Your Ref: OWPC26232
Our Ref: LU/363/19/PL 08-12-2019
Please ask for:
Andrew Wood

Change of use from 9 unit house in multiple occupation (HMO) to 10 unit HMO.
51 Arundel Road Littlehampton

PROPOSED

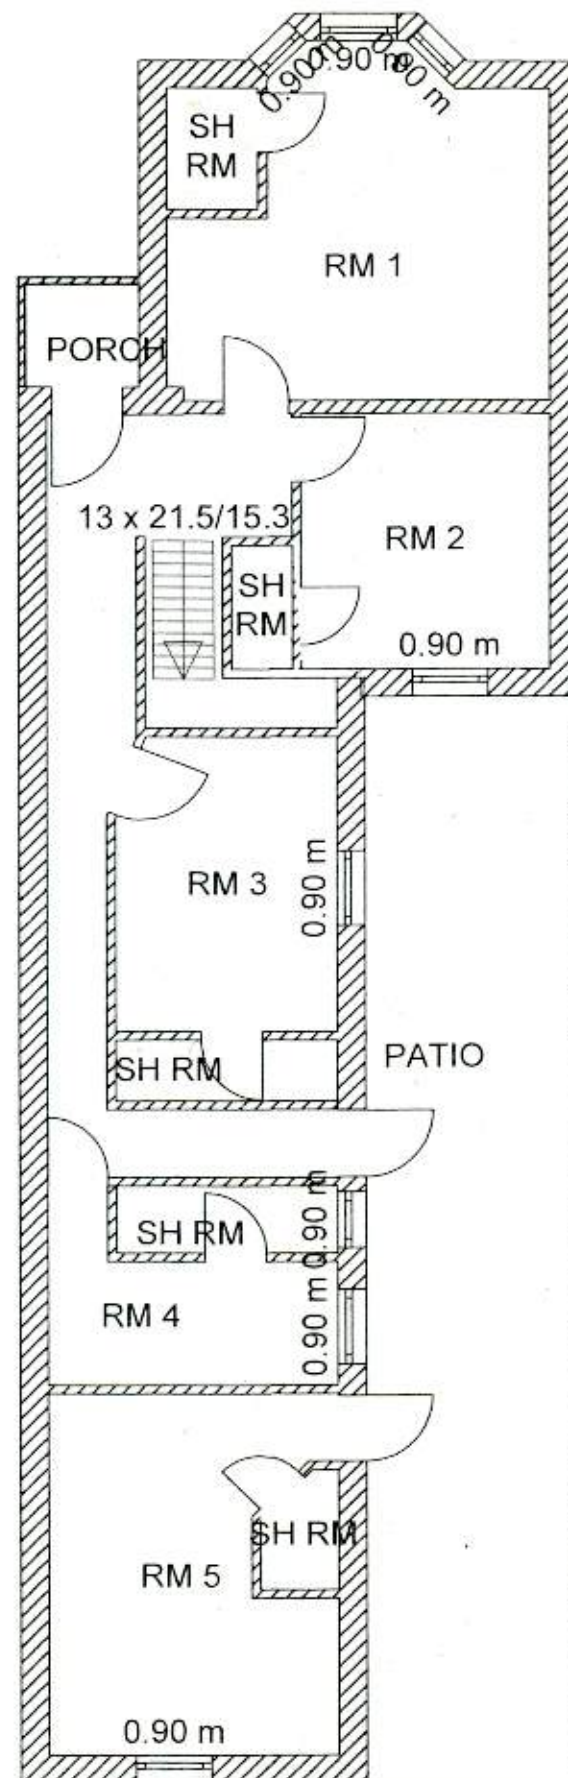
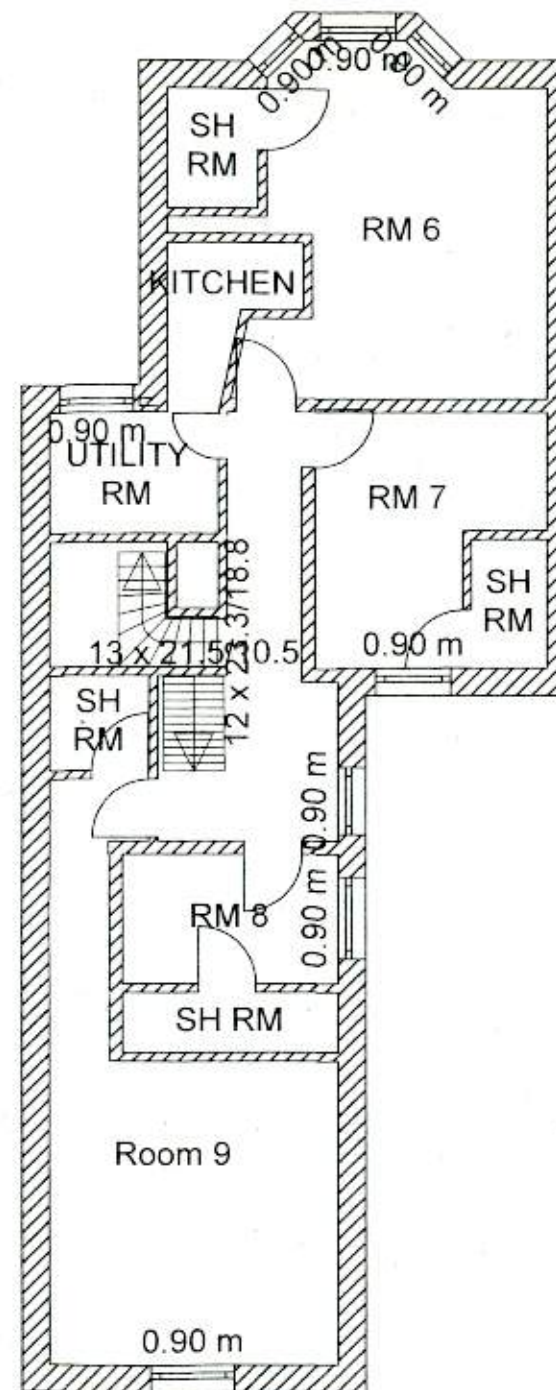
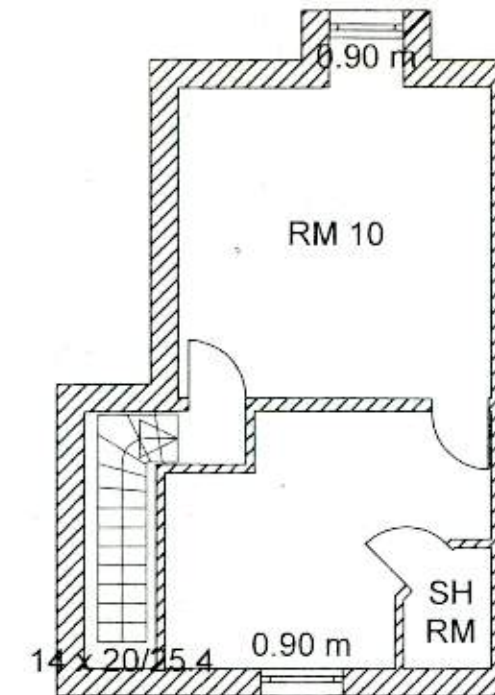
Littlehampton Town Council object object on the grounds that the application lacks detailed information regarding the room sizes and whether the proposals meet the minimum space standards, and an Environmental Health assessment of the appropriateness of the premises to accommodate 11 people with shared kitchen facilities
